CITY OF ALBUQUERQUE

**RE: Lot 8 Block 8 Unit 18 Volcano Cliffs SAD 228
6511 Canavio Pl NW
Grading and Drainage Plan
Engineers Stamp Date 5/20/16 (D10D003O8)**

Based upon the information provided in your submittal received 5/20/16, this plan cannot be approved for Grading Permit Revision for Retaining walls until the following comments are addressed.

GRADING & DRAINAGE PLAN 6511 CANAVIO PLACE, NW

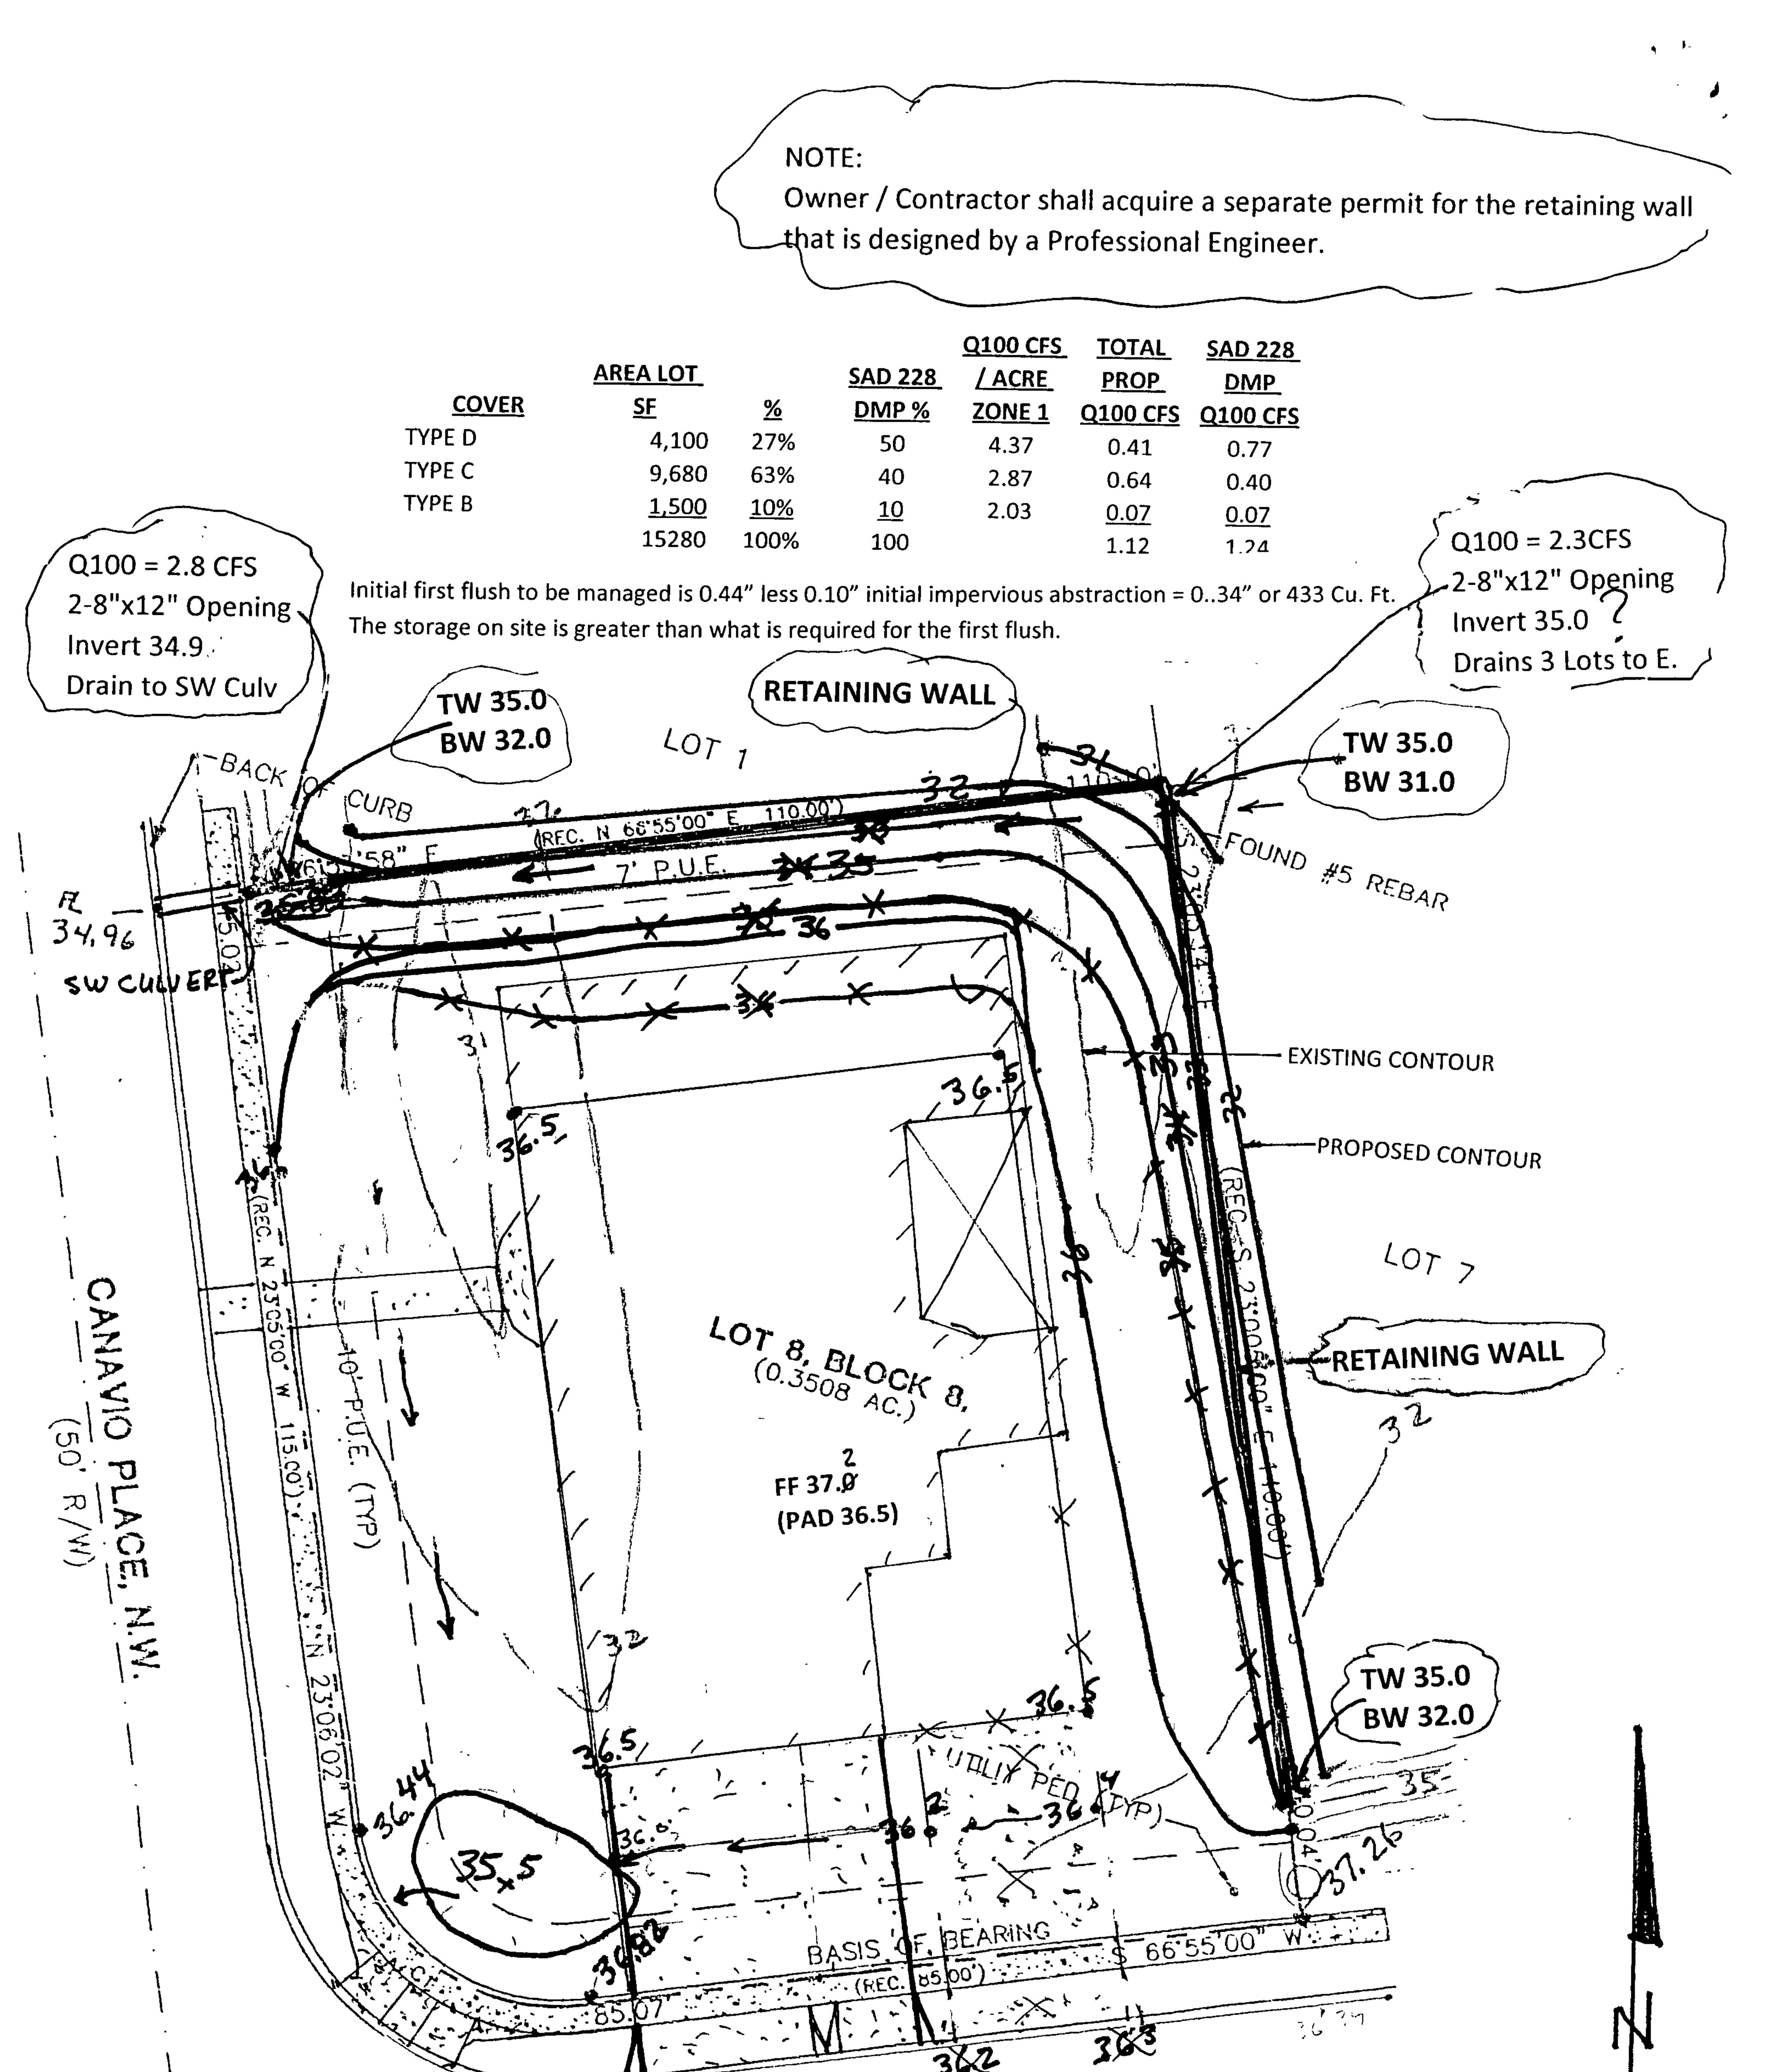
- Provide flows for this property which exit out to Canavio Pl NW.
- The invert at the NE corner is incorrect; the properties to the east will not be able to release their flows as is required by the master drainage plan.
- Provide a swale from the Northeast corner to the Northwest corner, with a desiltation pond near the sidewalk culvert, unless the swale is made of gravel. The swale should be at least 1 foot away from the property line to avoid compromising the retaining.
- The retaining walls need to be certified by this Engineering Firm or another.
- Provide an as built drawing for the site since grades were changed.
